## Response to Comments 1342 Congress Street - Proposed Neighborhood Center

**To:** Jean Fraser, Planner; City of Portland  
**FROM:** Greg Halsey, Tighe & Bond, Inc.  
**CC:** Steve Brinn, Jewish Community Alliance of Southern Maine  
**DATE:** May 8, 2015

**A. Reviewer: David Senus, P.E. Woodard & Curran  
Date: May 1, 2015**

GRADING, DRAINAGE, AND EROSION CONTROL PLAN

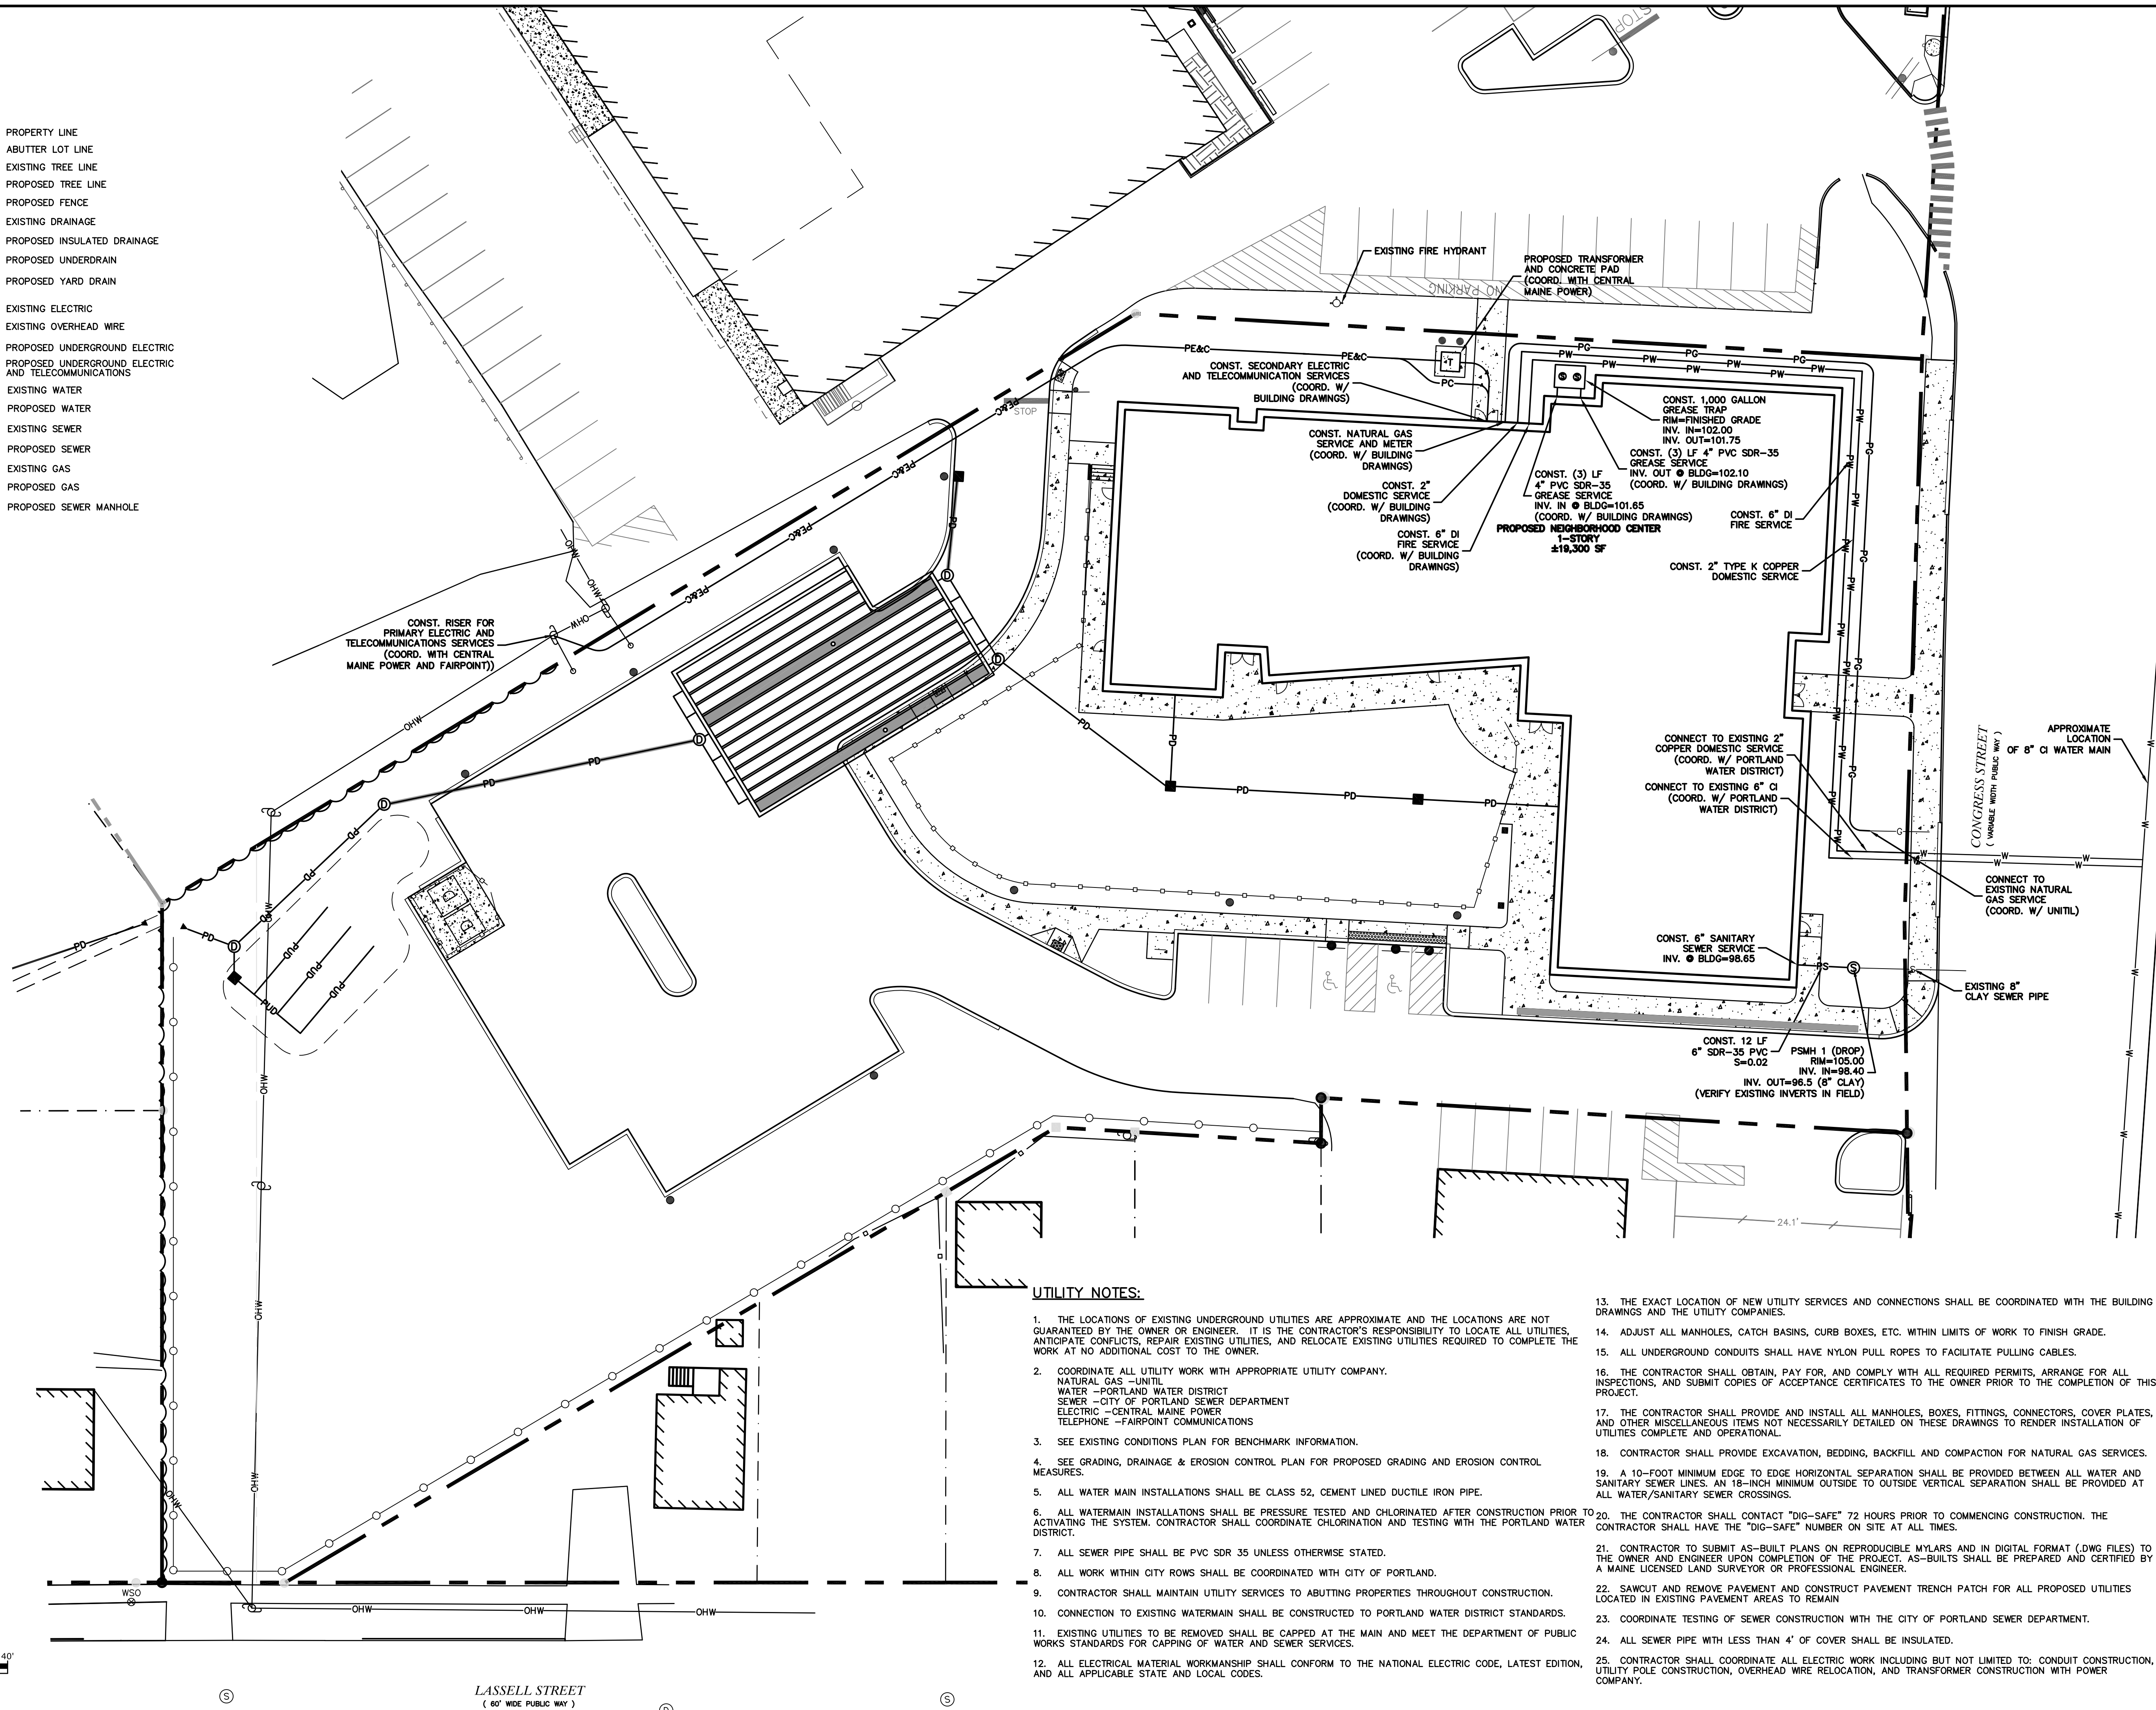
*treatment of runoff directed to filter BMPs due to topographic and geometric constraints of the site. Pre-treatment is particularly important for filter systems to ensure that sediment does not clog the filter and impede its function. It appears that there is ample space on the southern portion of the site to provide the MaineDEP recommended forebay area. We recommend that the applicant include a sediment forebay at the inlet point to the filter.*

- 4) *Sheet C-2b depicts snow storage along the east edge of the rear parking lot, adjacent to several residential properties. The grading plan (C-3) indicates that runoff from this area would potentially flow onto these properties. The Applicant should limit snow storage in this area and should revisit the proposed grading to ensure that runoff from the project property is not directed onto these abutting residential lots.*

**A sediment forebay has been provided at the inlet to the Underdrained Soil Filter. A waiver from the pretreatment requirements is no longer requested. See Sheet C-3 Grading, Drainage, and Erosion Control Plan included with this response.**

**The proposed grading in this area has been revised to provide a shallow swale that will convey runoff from snow melt or rain to the rear of the site and away from abutting properties, which is consistent with the existing drainage pattern in this area.**

CROSS SECTION UNDERDRAINED SOIL FILTER
DETAIL
NOT TO SCALE

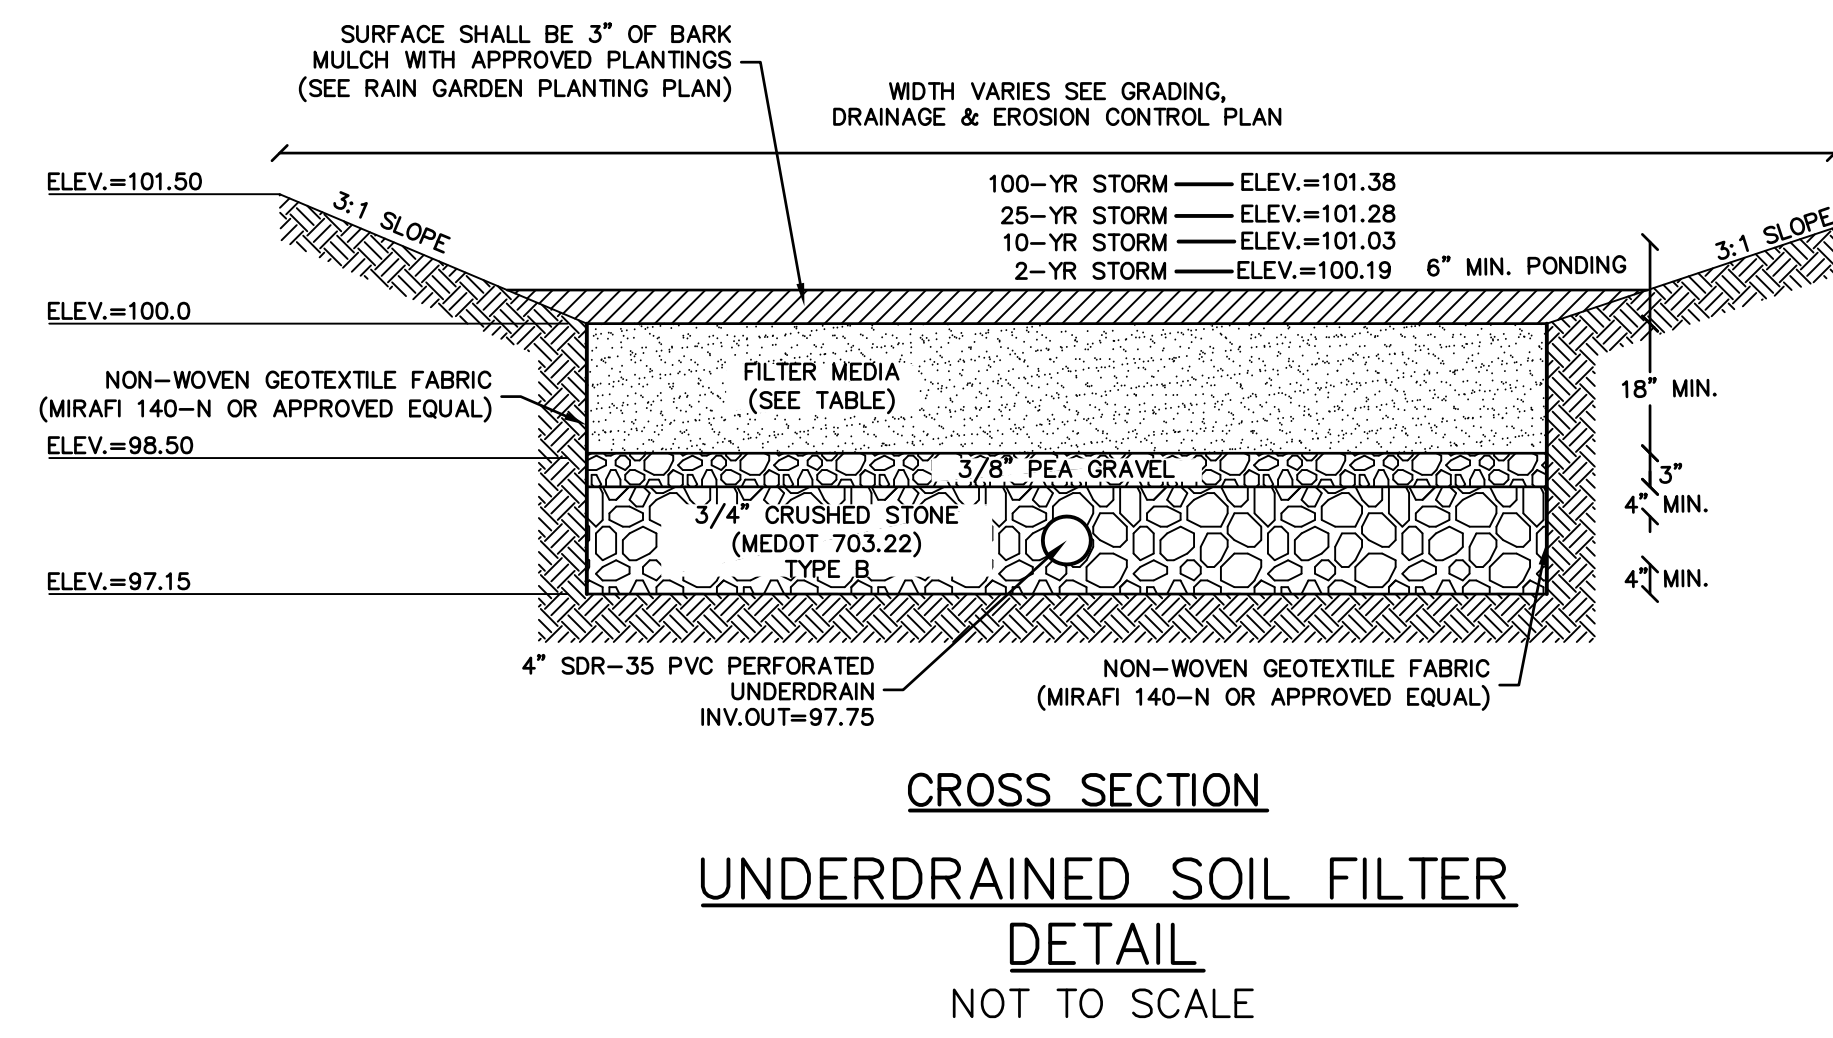
- 6) *The proposed Underdrained Soil Filter Bed detail refers to a Rain Garden Planting Plan for proposed plantings; however, it does not appear that this plan has been provided at this time.*

**The Landscape Plan, Sheet L-1, included with the Preliminary Site Plan Submission acknowledges plantings are needed in this area, but provided no specifics on plant species or layout. The Landscape Plan, Sheet L-1, will be updated to include an appropriate planting plan for the Underdrained Soil Filter with the Final Site Plan Submission.**
